31 January 2018

File No: SSD 8373  
Our Ref: R/2017/9/A

**State Significant Development application for the Alexandria Park Community School Redevelopment, Park Road, Alexandria (SSD 8373)**

SHADOW DIAGRAMS

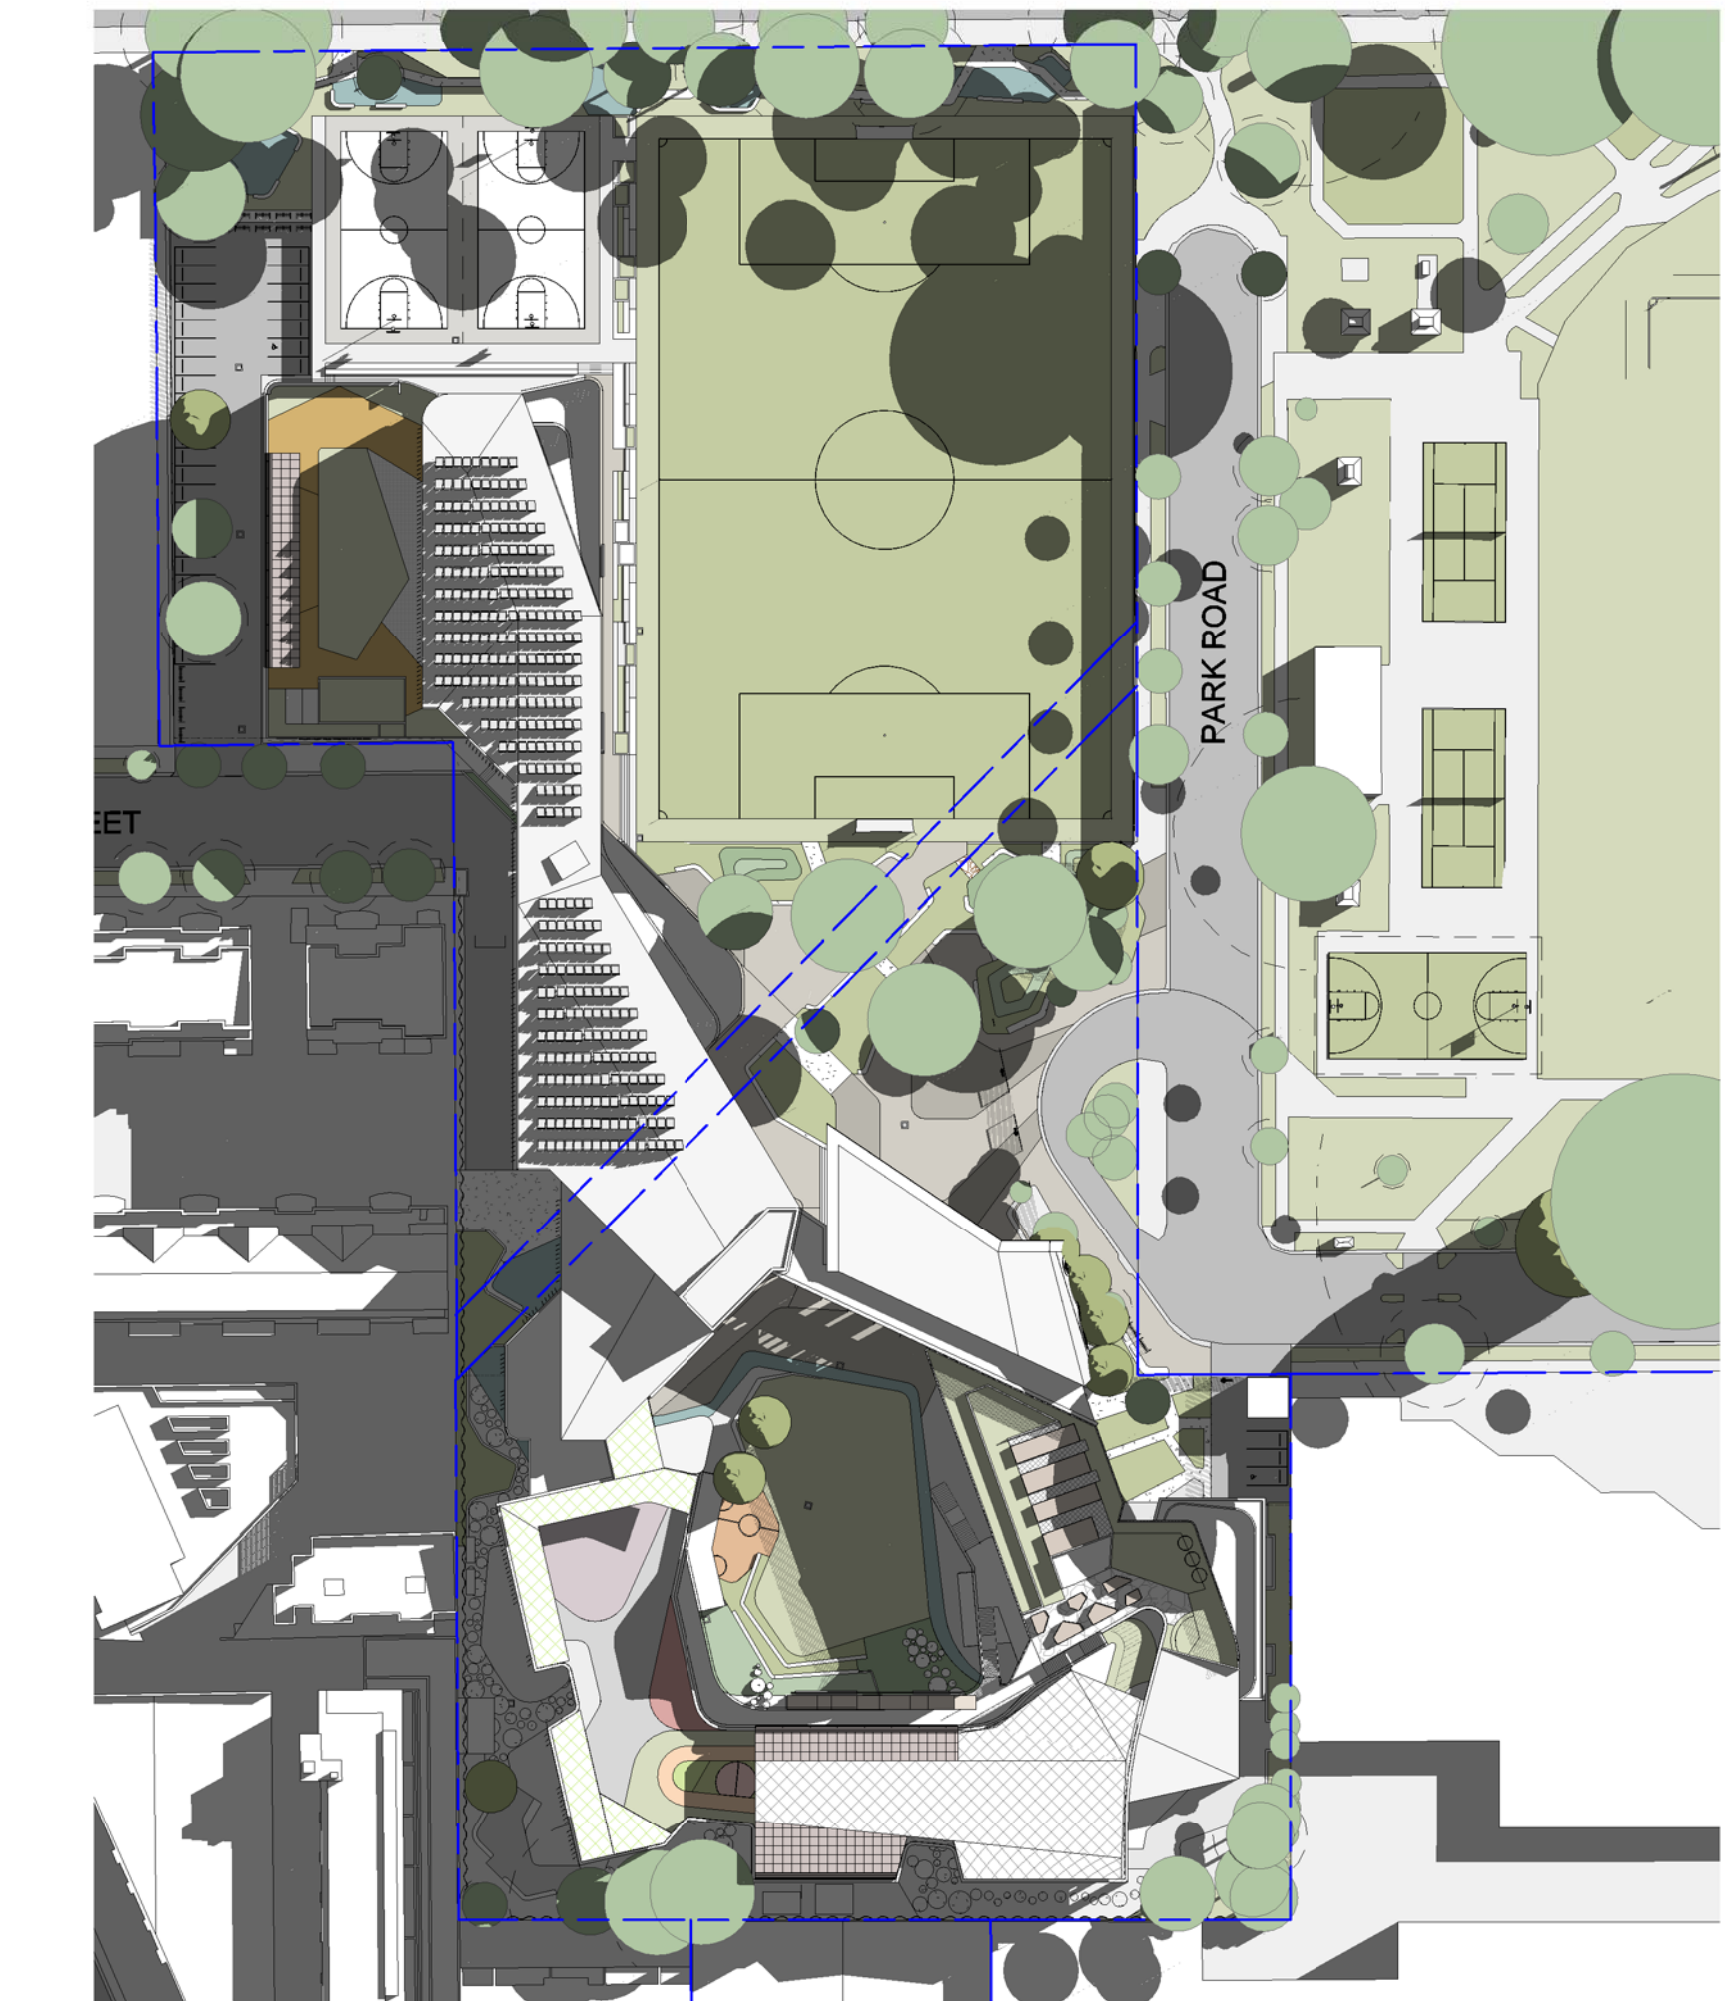
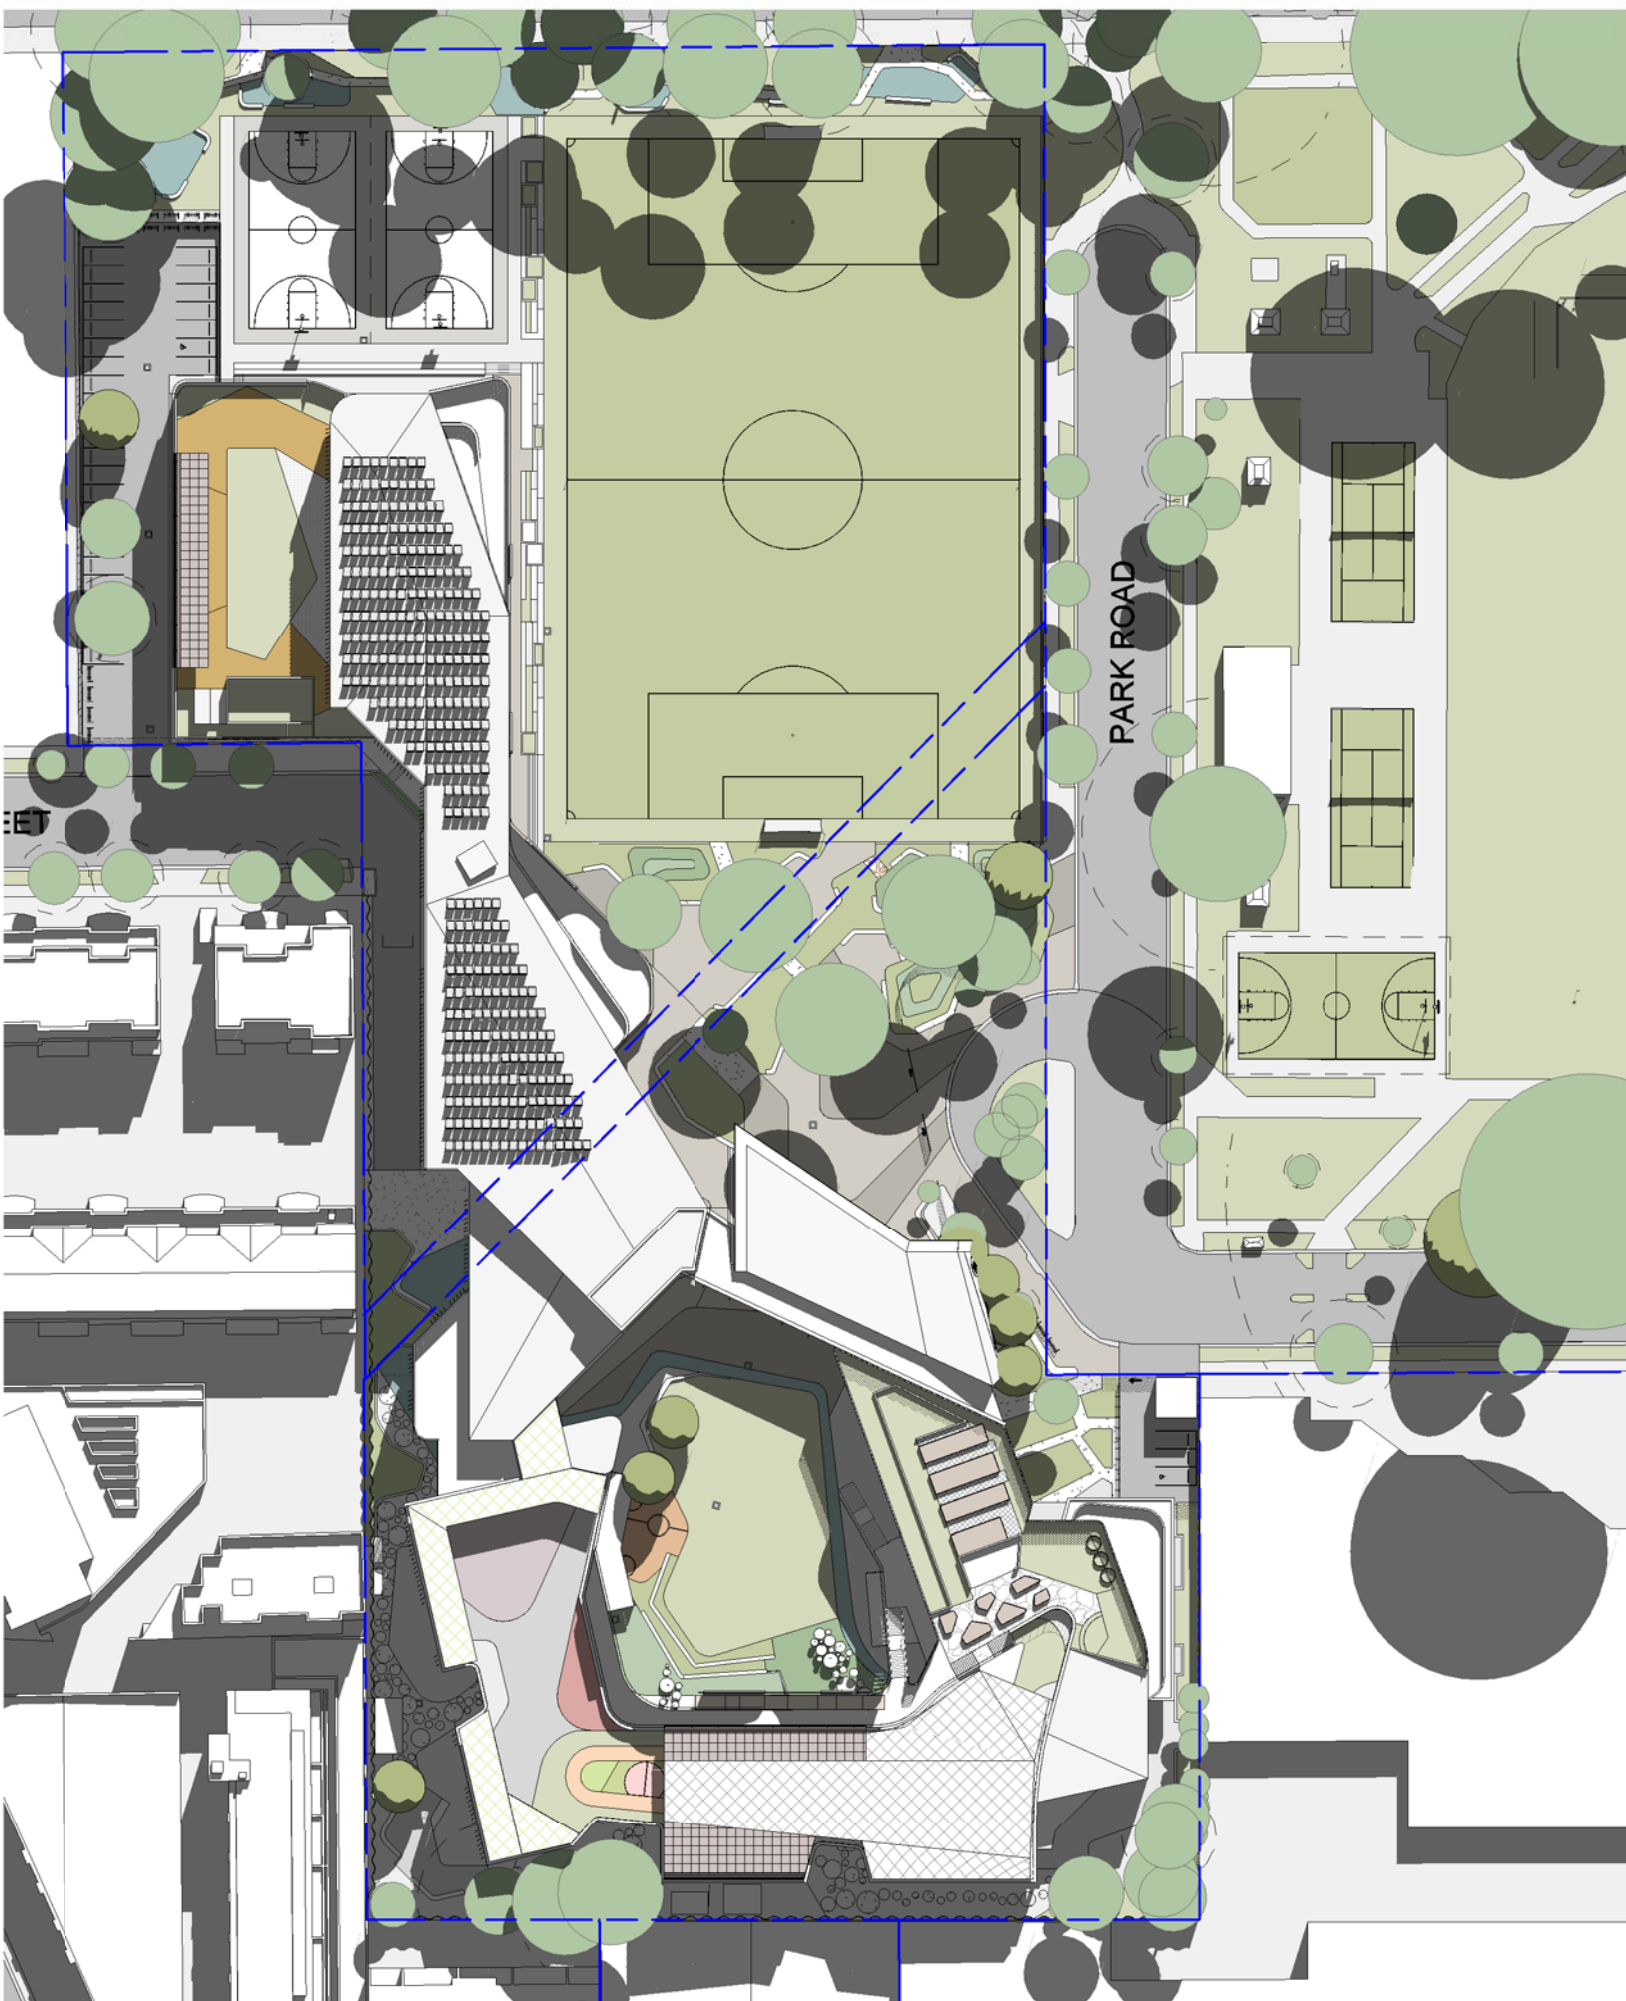
The shadow studies provided at 9am, 12pm and 3pm in midwinter do not provide sufficient detail to fully assess the amenity impacts on adjoining properties. In order to undertake a detailed analysis of the overshadowing impacts, additional material in the form of detailed views from the sun at hourly intervals would need to be provided in relation to the affected properties. Each neighbouring apartment would need to be counted individually and the analysis would need to provide both existing and proposed hours of solar access to living room windows, private and communal open space.
